Consultation Response from: KC Environmental Health (Pollution & Noise Control)
2026/92061 Land adj, 17, Whitehall Road West, Birkenshaw, BD11 2LS
Discharge of details reserved by conditions 6 (coal remediation) and 11 (verification report) on previous permission 2024/92281 for erection of 23 dwellings
Responding Date:
20/08/2026

Environmental Health has reviewed the submitted information that relates to the Contaminated Land specifically Condition 11 (Verification Report).

Letter report by ARP Geotechnical Ltd. RE: Whitehall Road West, Birkenshaw. Garden Soils Validation - Plot 1. Ref: ORH/20/JPjcl4 dated 27th July 2026.

Title
PLOT 20 AND 21
GARDEN VALIDATION

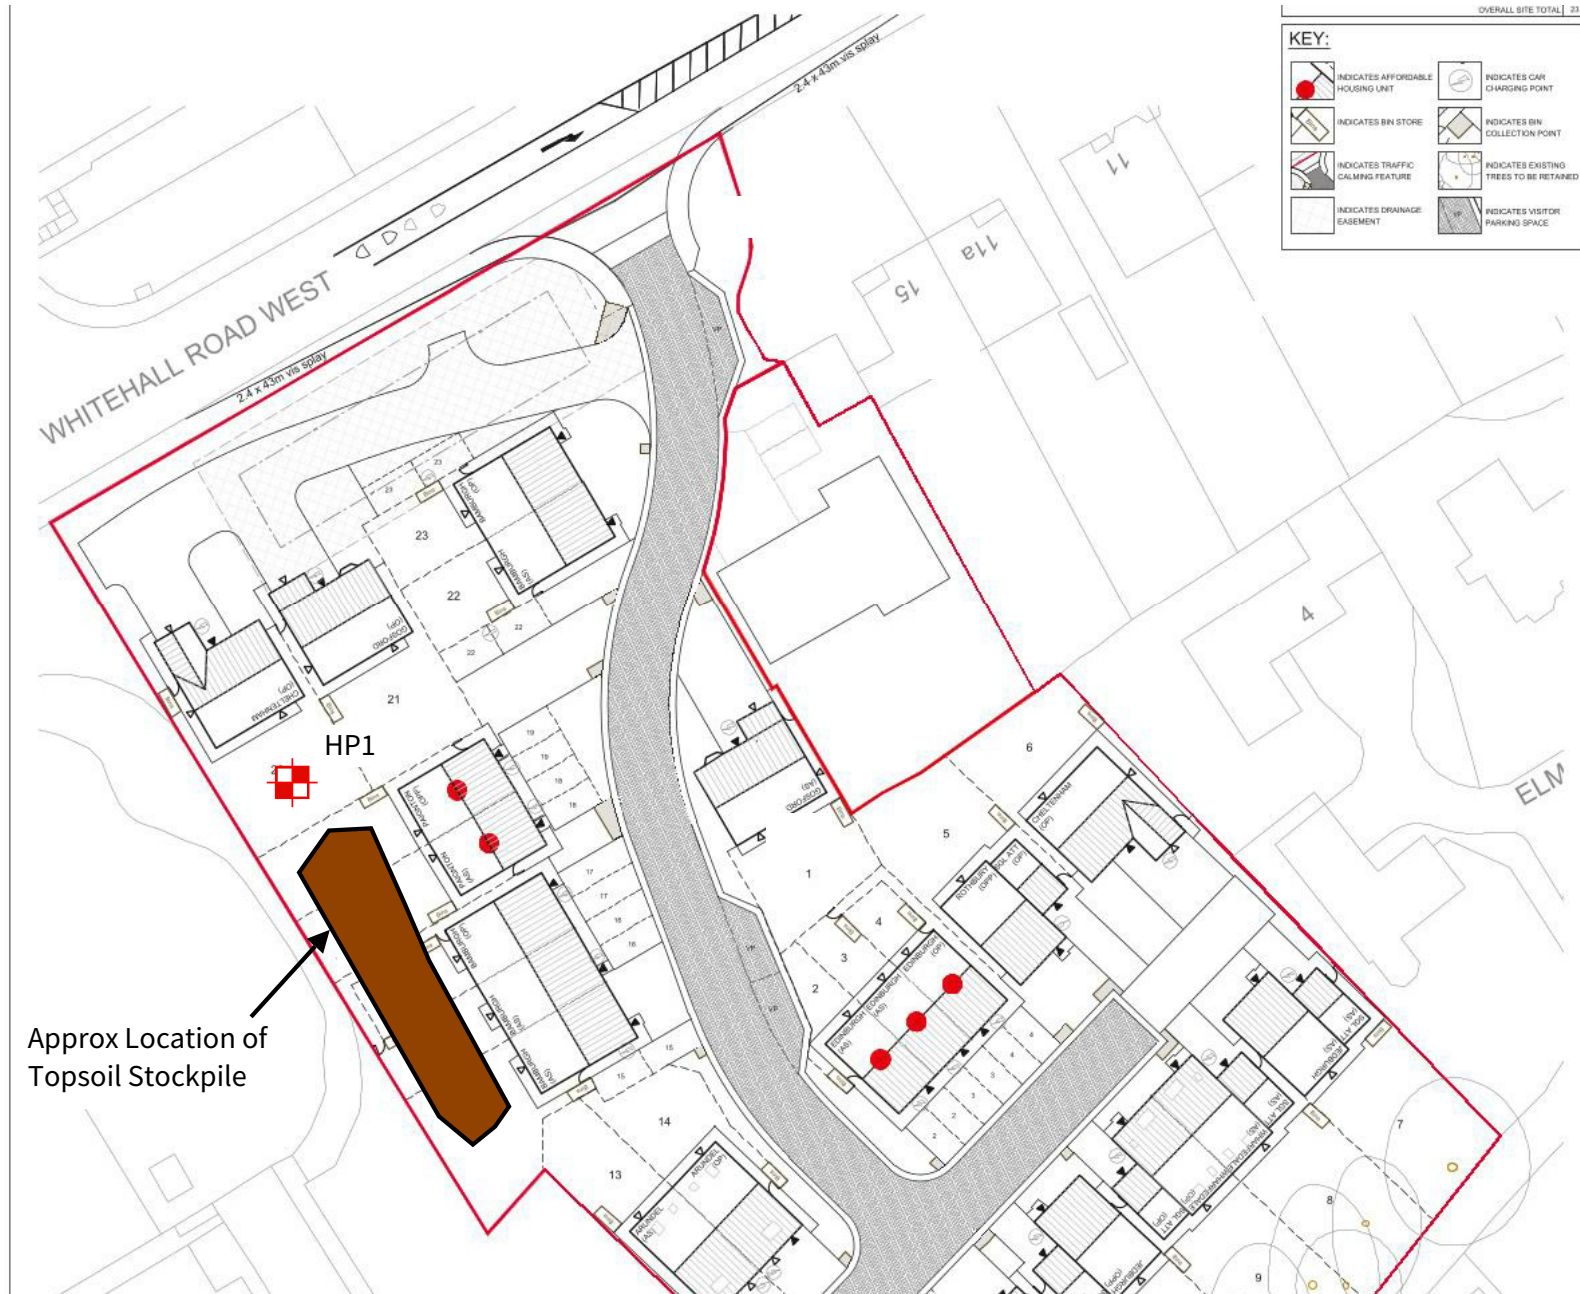
The submitted information provides partial validation of garden soils and cover depths for selected plots (Plots 1, 15, 17, 19 and 21) with a further seven samples required to demonstrate the agreed sampling frequency.
